Application by Morgan Offshore Wind Limited and Morecambe Offshore Windfarm Limited for the Morgan and Morecambe Offshore Wind Farms Transmission Assets

Preston City Council's answers to the Inspector's questions – 7th July 2025

Figure 1.2: Construction Noise - Location Plan (Onshore Export Cable Corridor, 400KV Grid Connection Corridor and Onshore Substations)

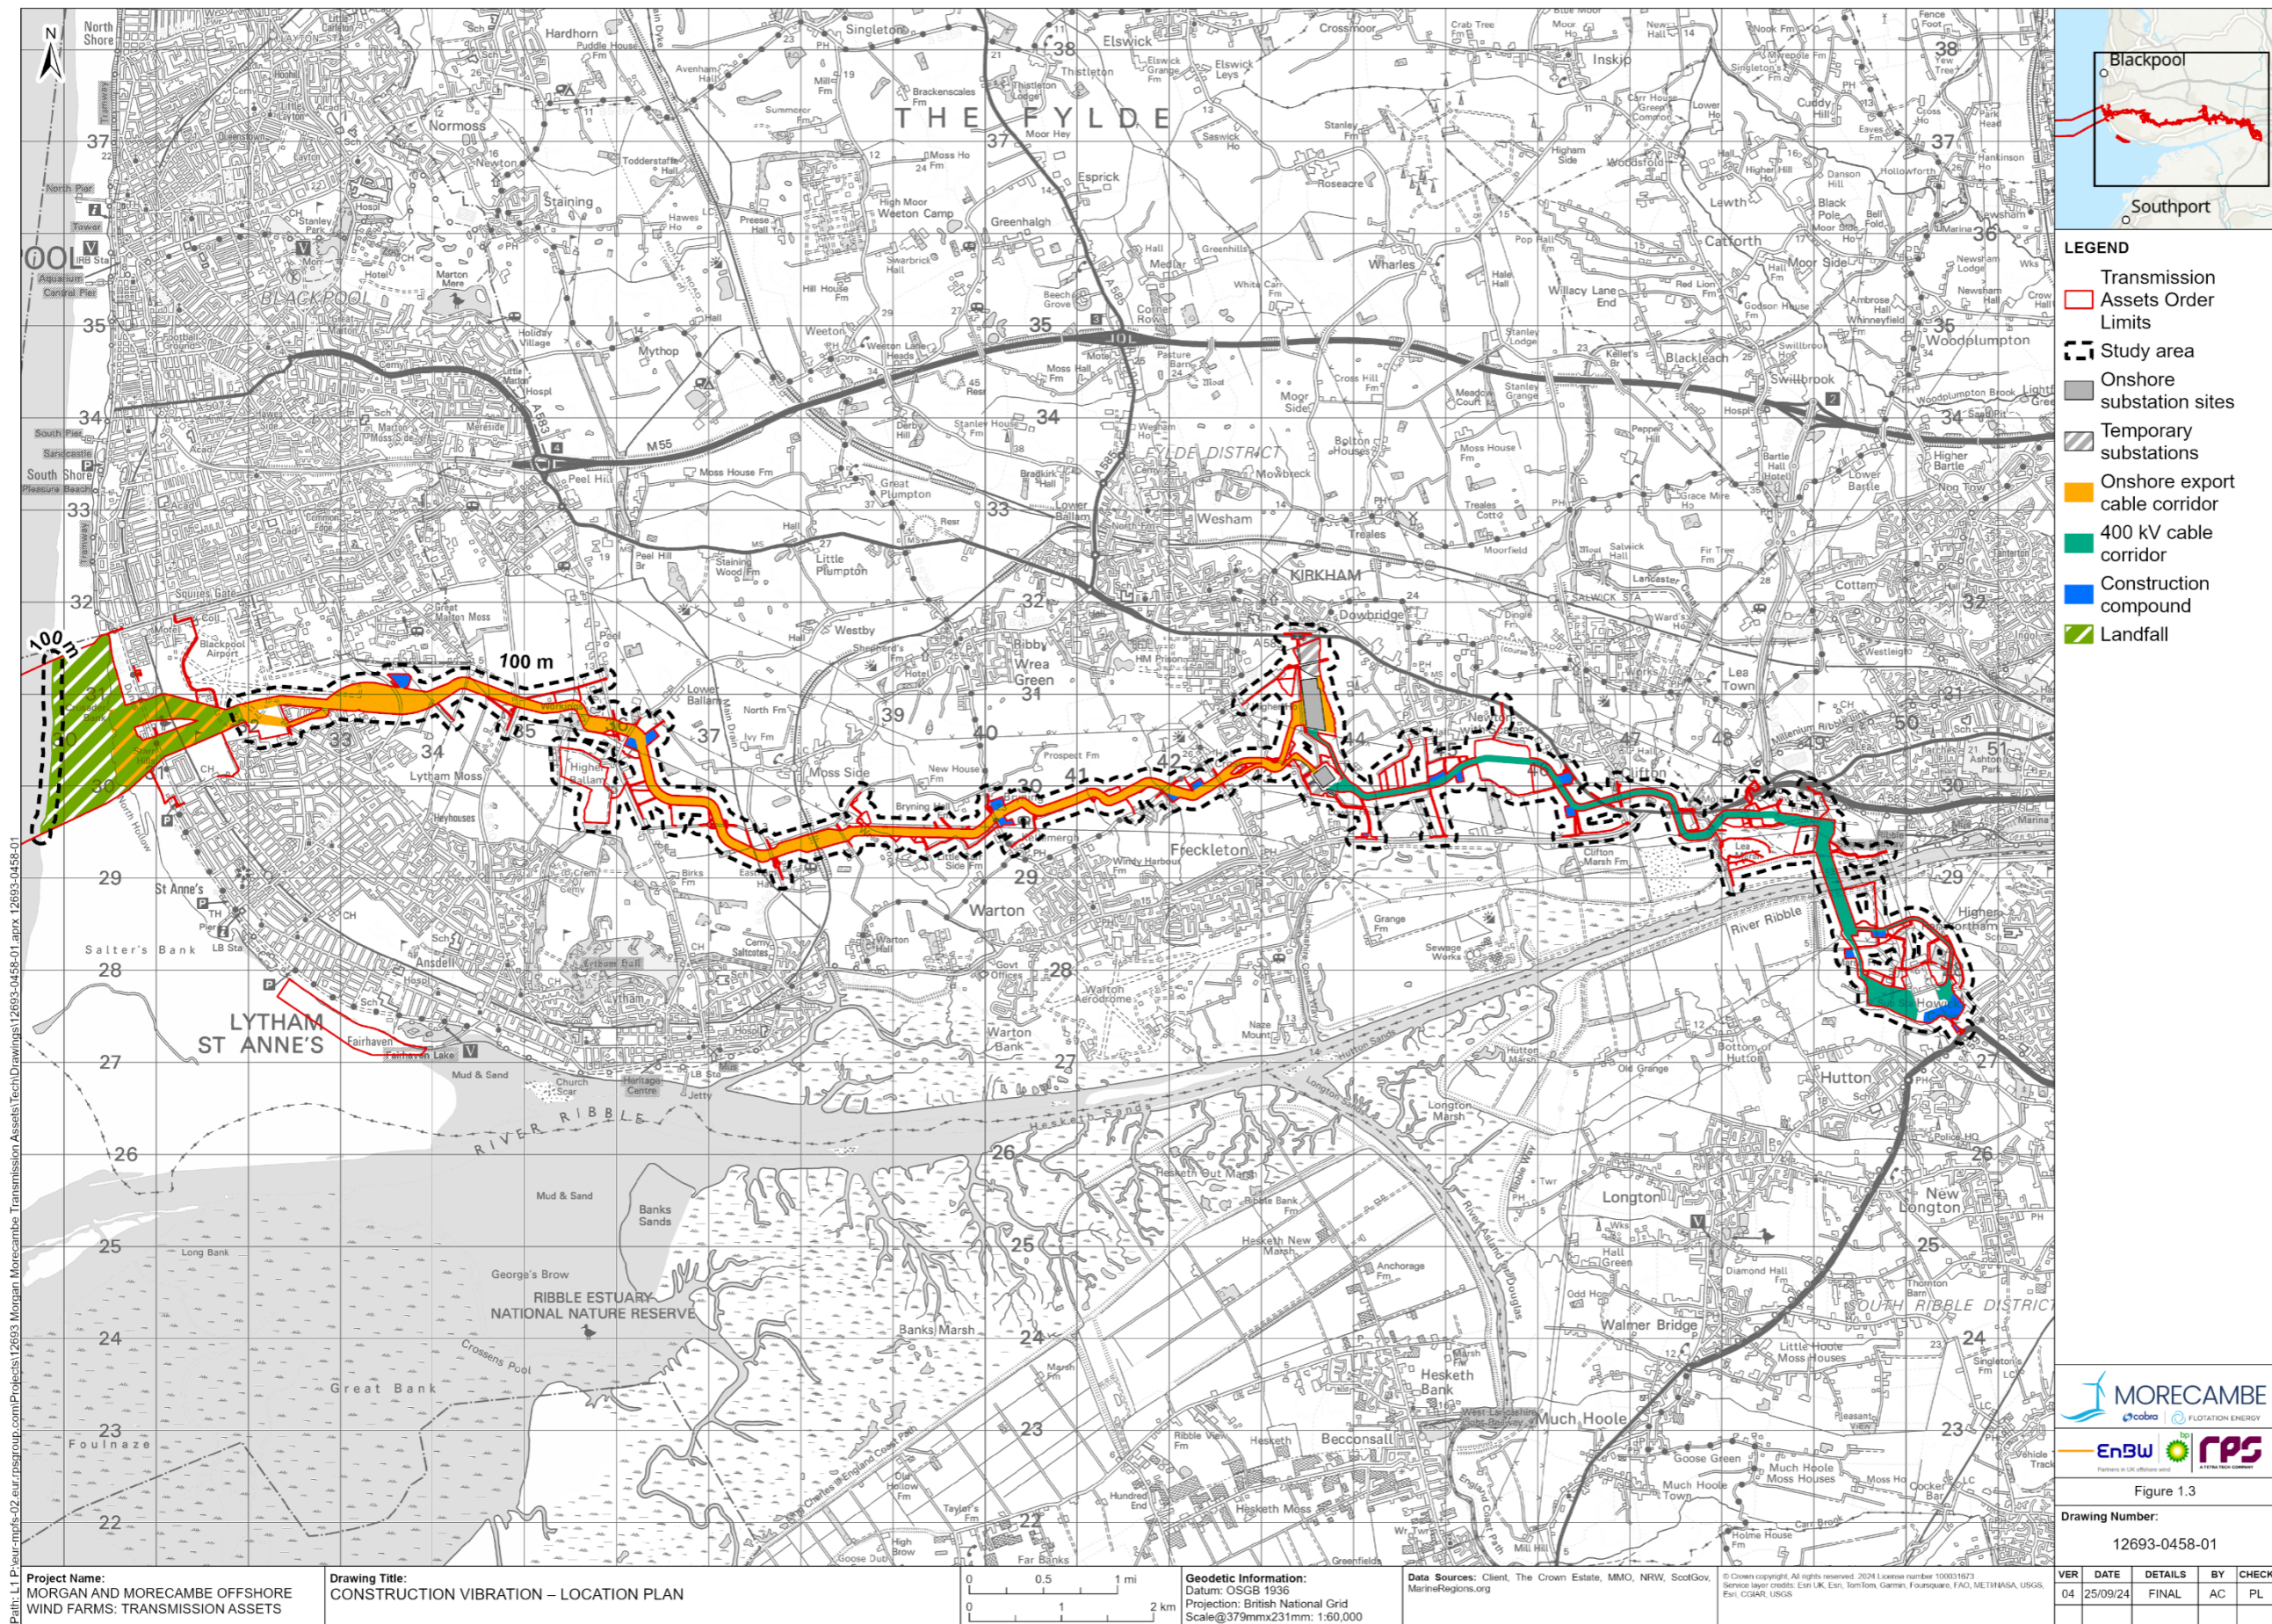
Within the Preston City Council (PCC) district area, the proposed development would not be located in close proximity to residential areas. However, there are residents living at Old Hall Farm, set to the east of the site, who may be affected by the proposed construction hours. Therefore, PCC would recommend construction hours 7am – 7pm Monday to Friday, 7am-1pm Saturdays and no working on Sundays and Bank Holidays.
